D. Mark Goodwin & Associates, P.A.
Consulting Engineers

May 5, 2008

Re: Chaparral Warehouse (H14/D060)

I have received your letter, dated April 30th, indicating three comments. Included herewith is our resubmittal of the referenced plan addressing those comments, as follows:

PROPOSED DRAINAGE BASINS
1"=30'

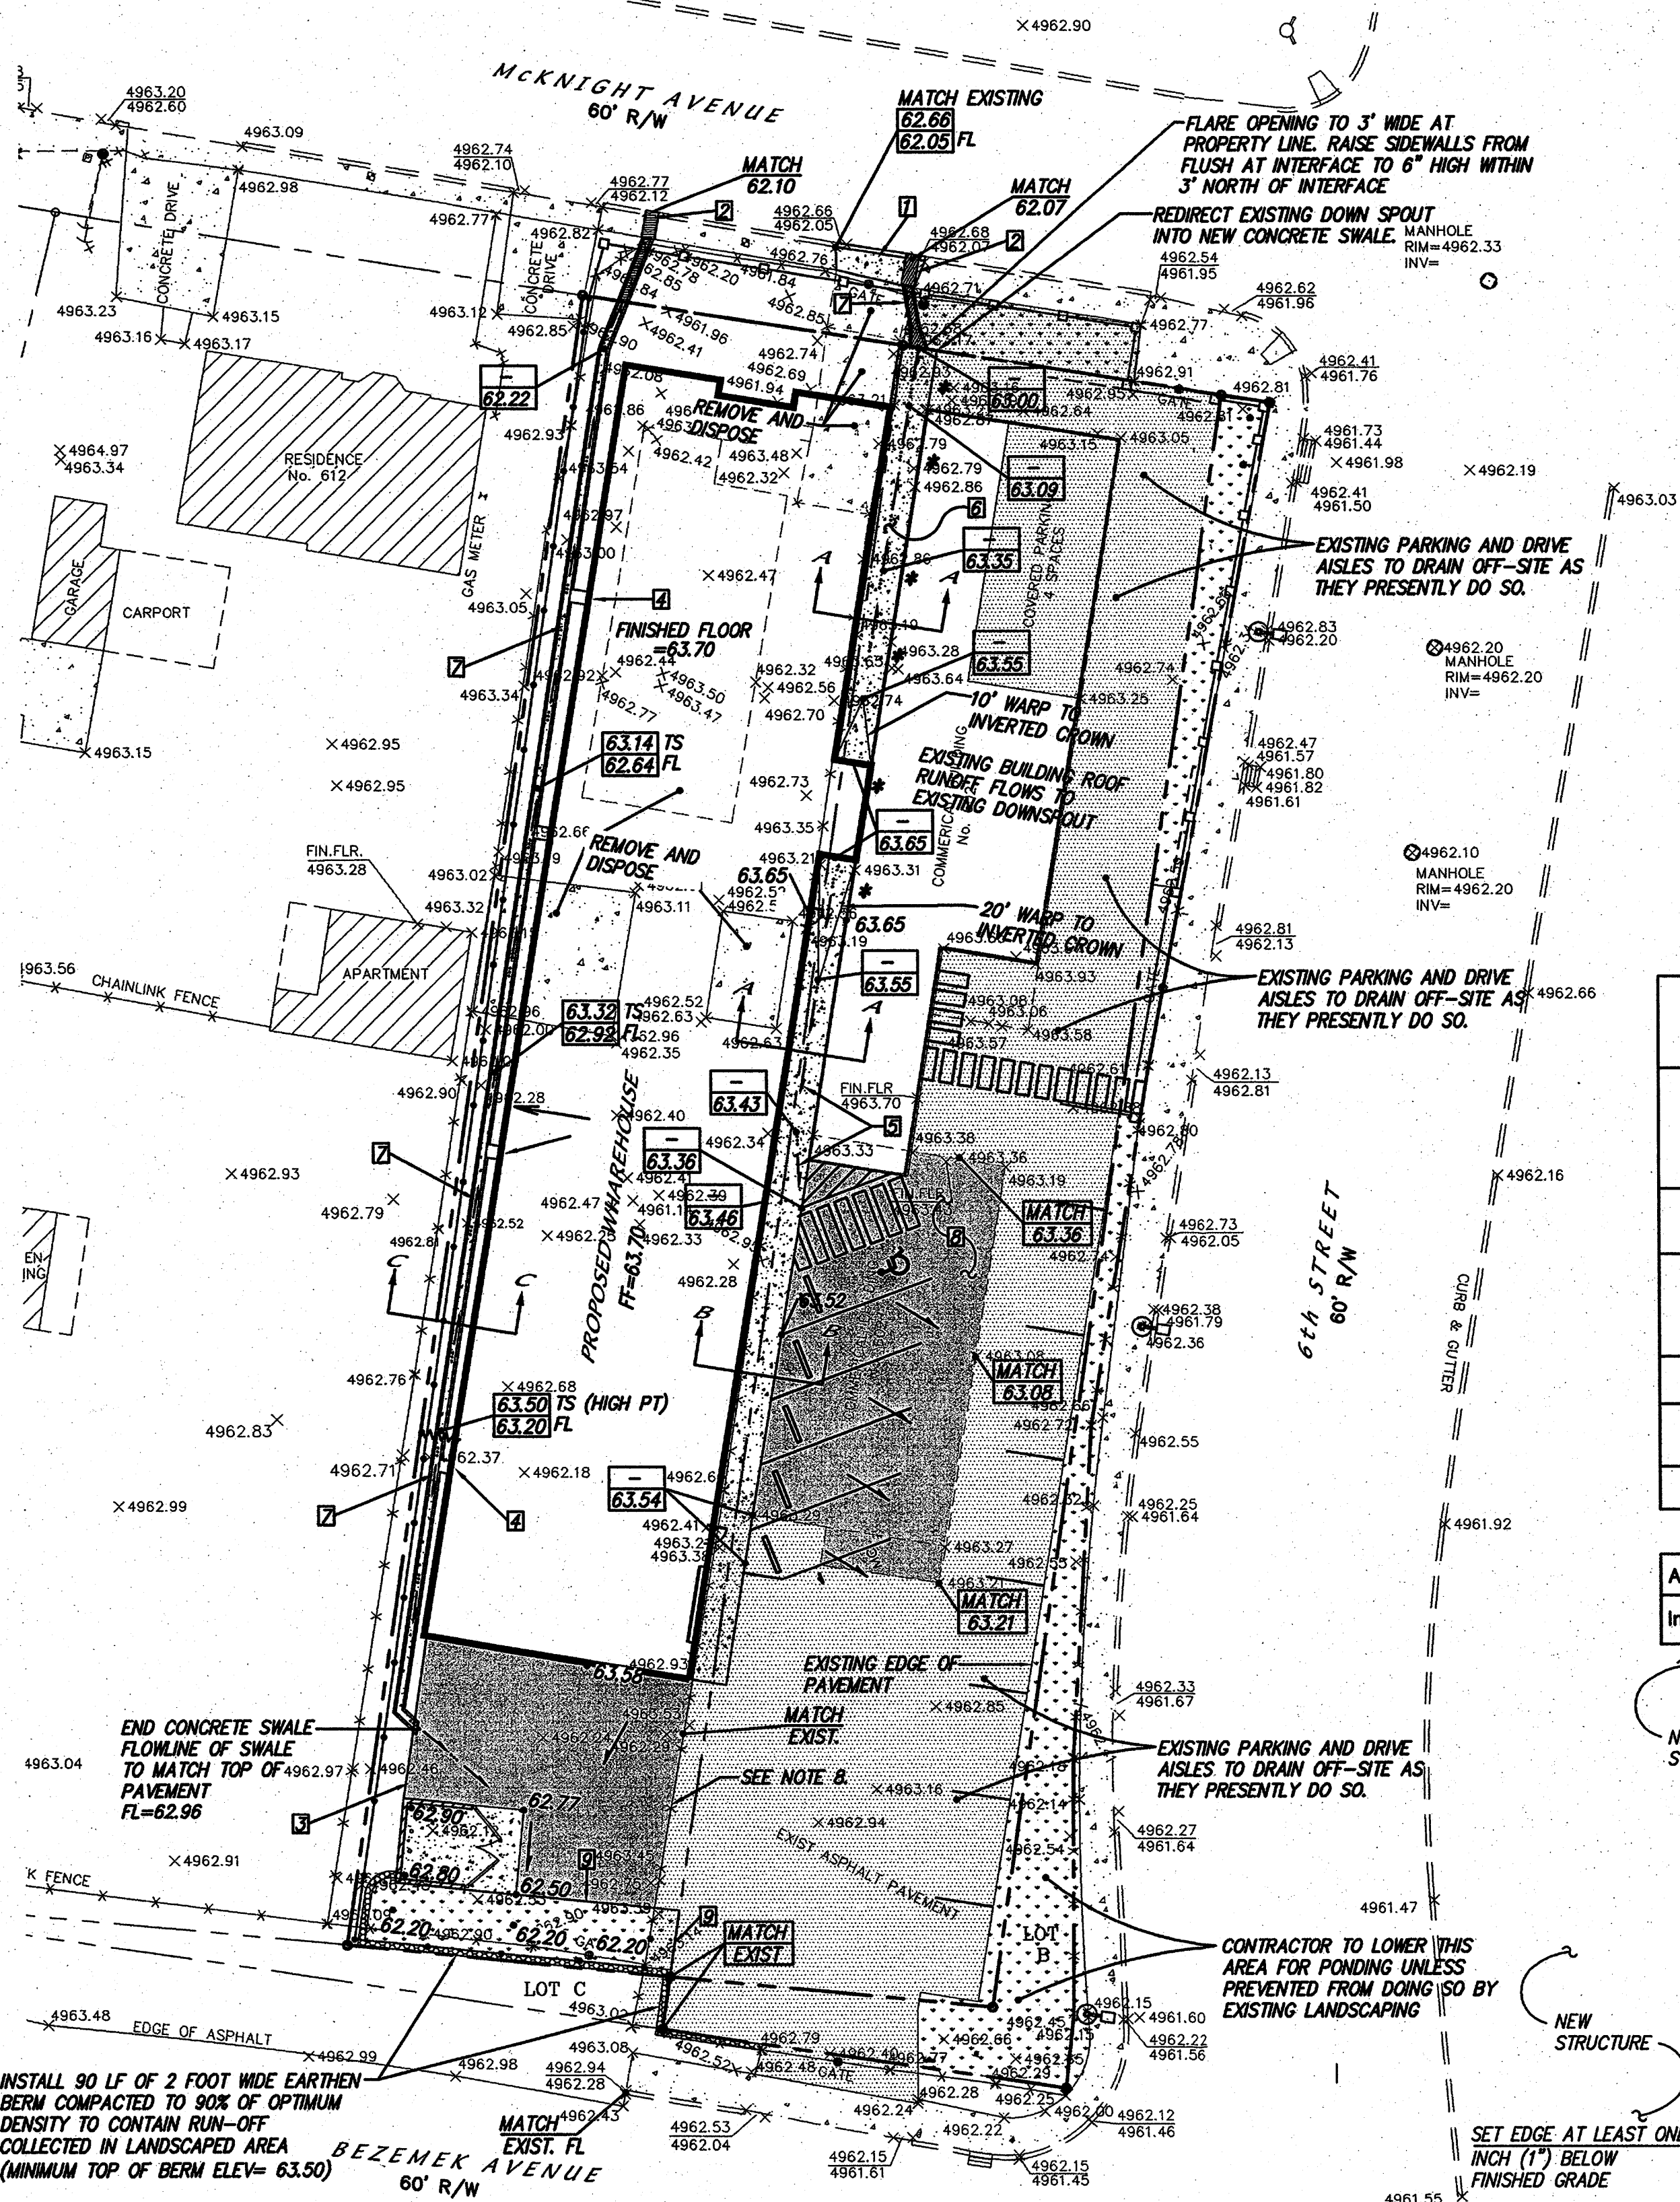
We have received a revised site plan from the architect that addresses the issue of the off-site property located on the south side of the site along Bezemek (Lot C). As a result, we have revised our plan accordingly. The plan now is to direct runoff from the site to the east instead of south out into Bezemek across the off-site property owned by others. To aid in the execution of this plan we have called for runoff to flow south into a landscaped area and then east across existing paving toward the SE corner of the site where there is more landscaping (into existing landscaping, as you had suggested previously). In order for this new runoff to be contained within the new landscaped area, I have called for the contractor to install an earthen around the west and south sides of the landscaping area to insure that runoff does not escape south from the landscaped area and cross onto Lot C (property of others).

On the attached plan there is now a callout for the contractor to extend the steel plates of the sidewalk culverts all the way up to the R/W line.

The solid line next to the property line along 6th Street is an existing edge of paving. It has been shaded to indicate that it is existing.
